Subject: RE: Planning Consultation on: F/17/20/DOC

Engineers Comments Regarding Surface Water Drainage

Application No: F/17/20/DOC
Registered: 3rd August 2020
Site Address: South Yard B Wicks Farm Ford Lane Ford BN18 ODF
Description of Works: Approval of details reserved by condition imposed under ref F/5/19/PL relating to Condition No 5 - surface water drainage

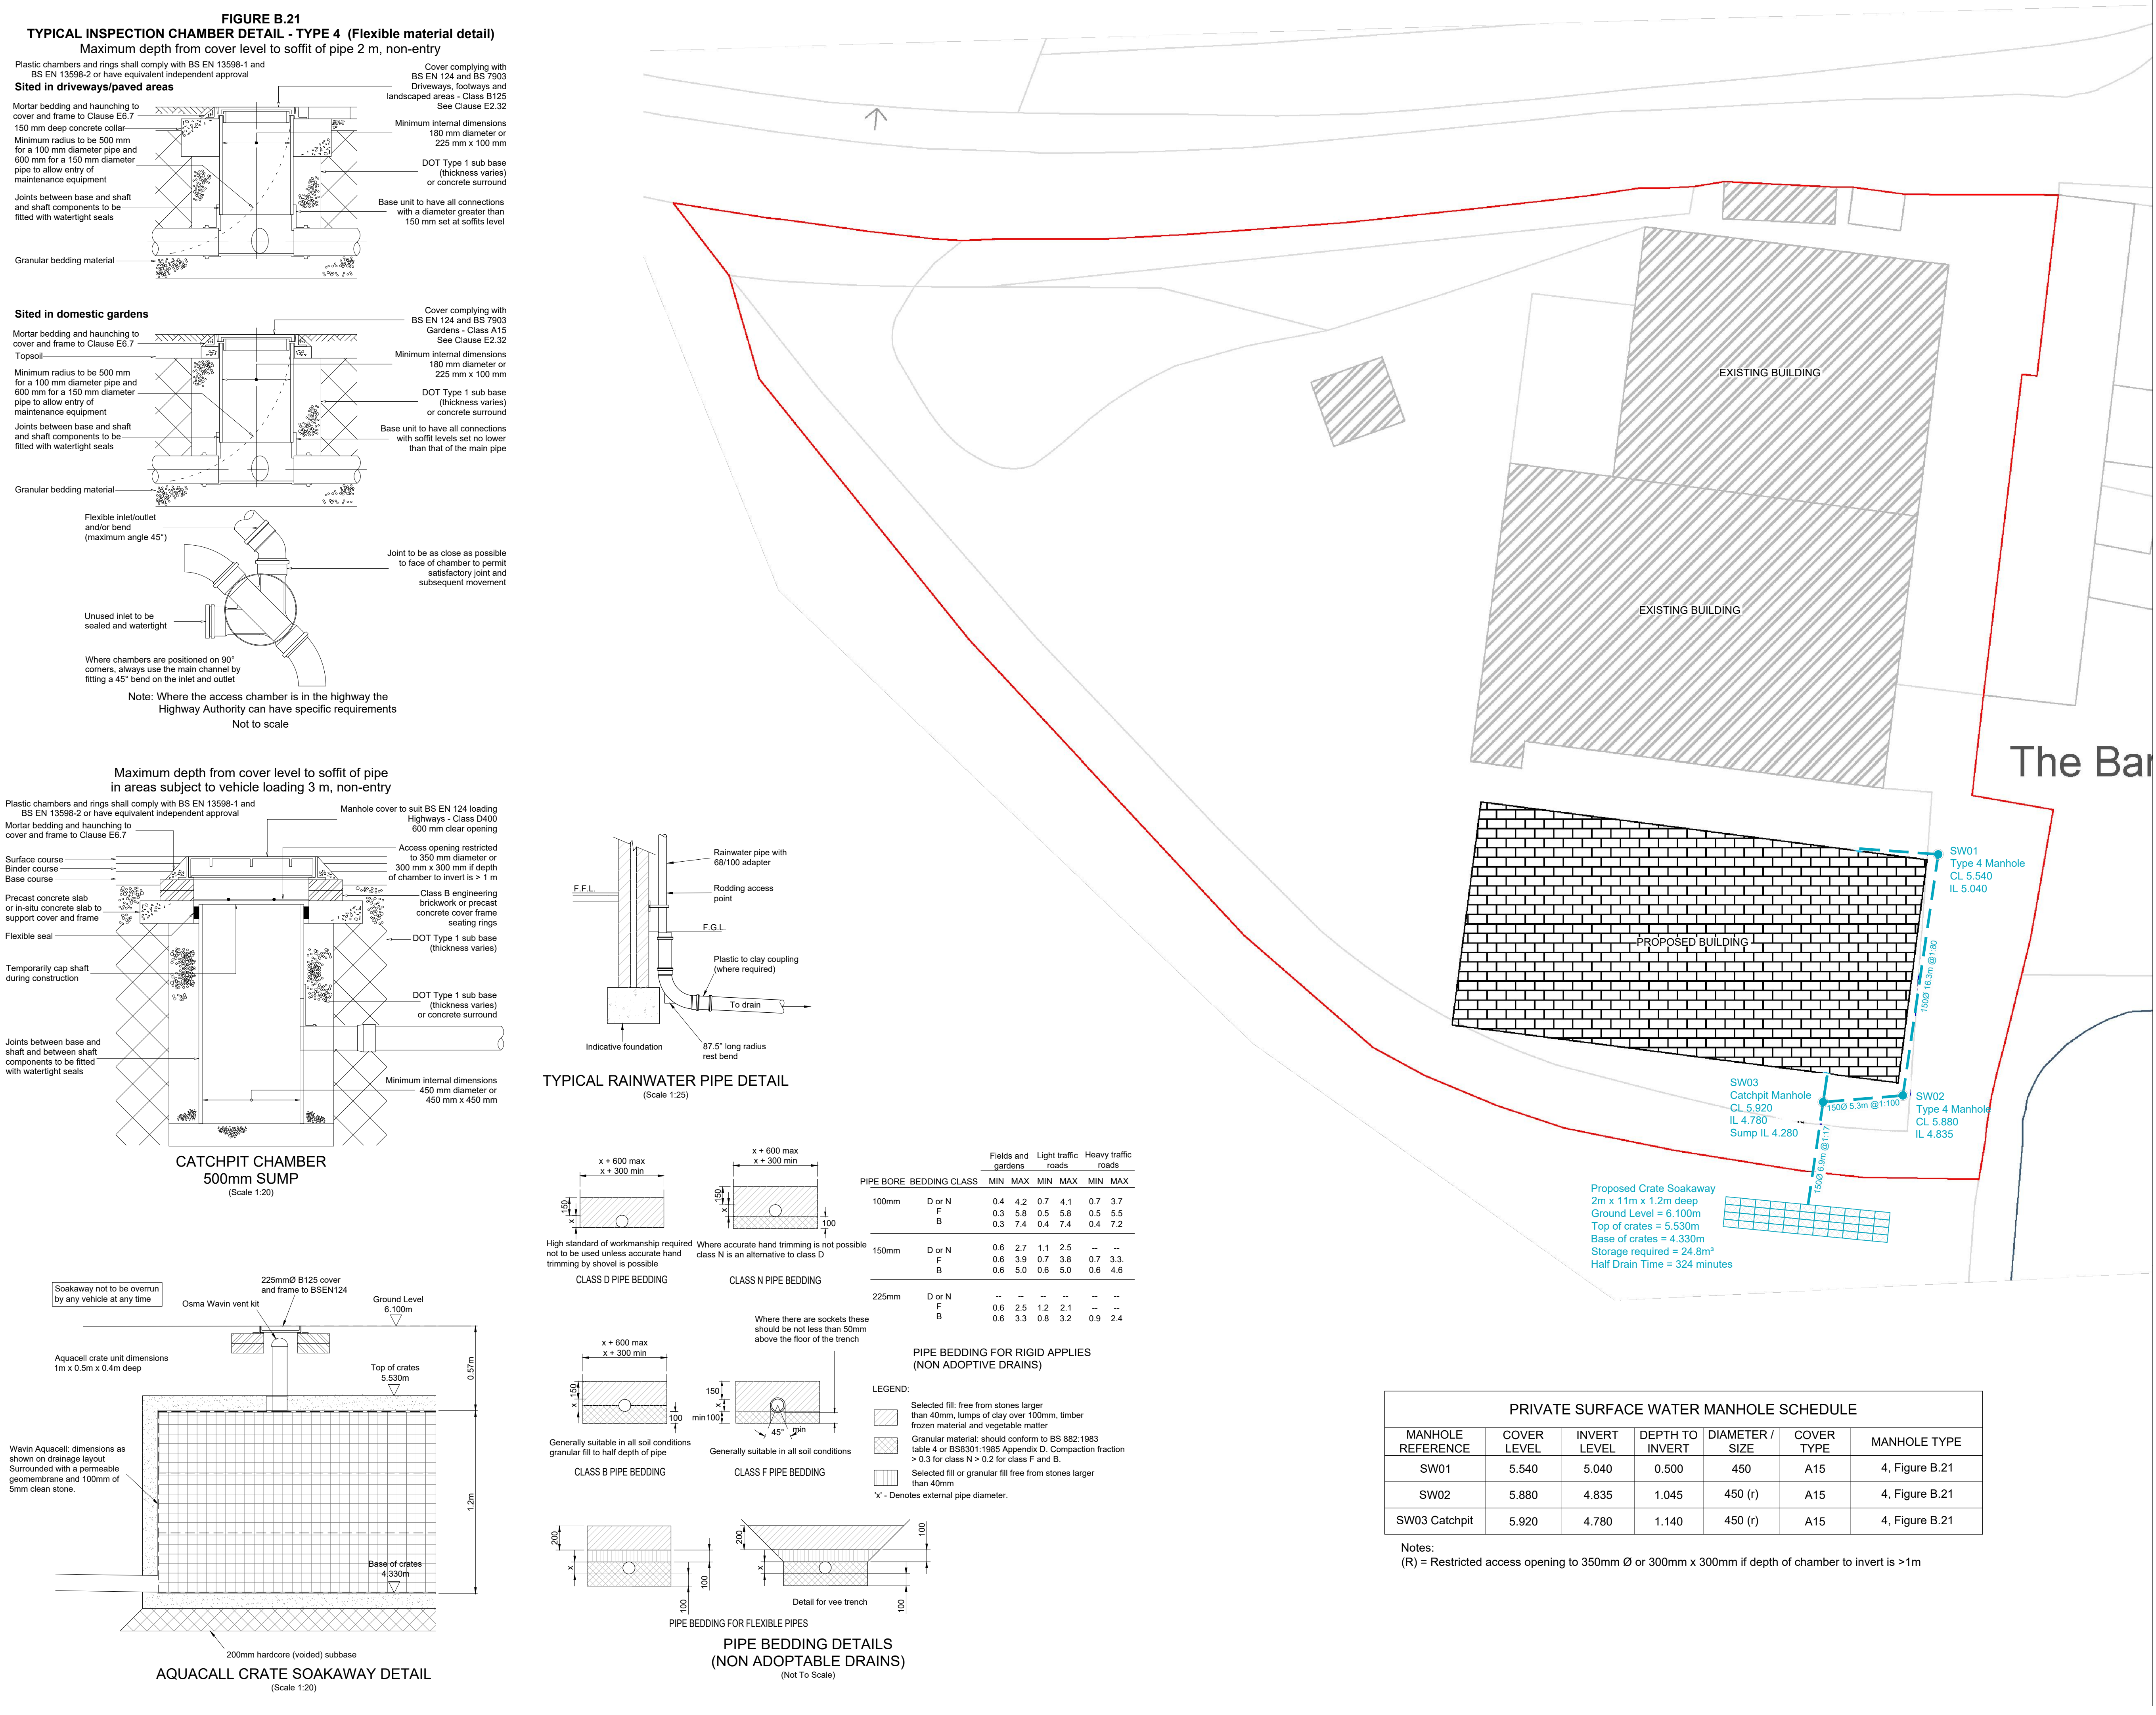
The incoming pipe to the soakaway is set at the base. Our requirements state that the 1 in 10 year storm must be catered for between the invert of the lowest entry pipe and the base of the infiltration structure. Please re set this pipe as high as possible and adjust both the invert level on the layout and the construction detail to reflect this.

I am concerned that the soakaway is shown to be in a location outside of the applicant's ownership (red line). Does the applicant have approval to be siting a soakaway outside of this site? I have checked the original application and there was no extended part of the site shown as the same ownership (blue line). If possible we would like to see the surface water drainage contained within the red line boundary for the site.
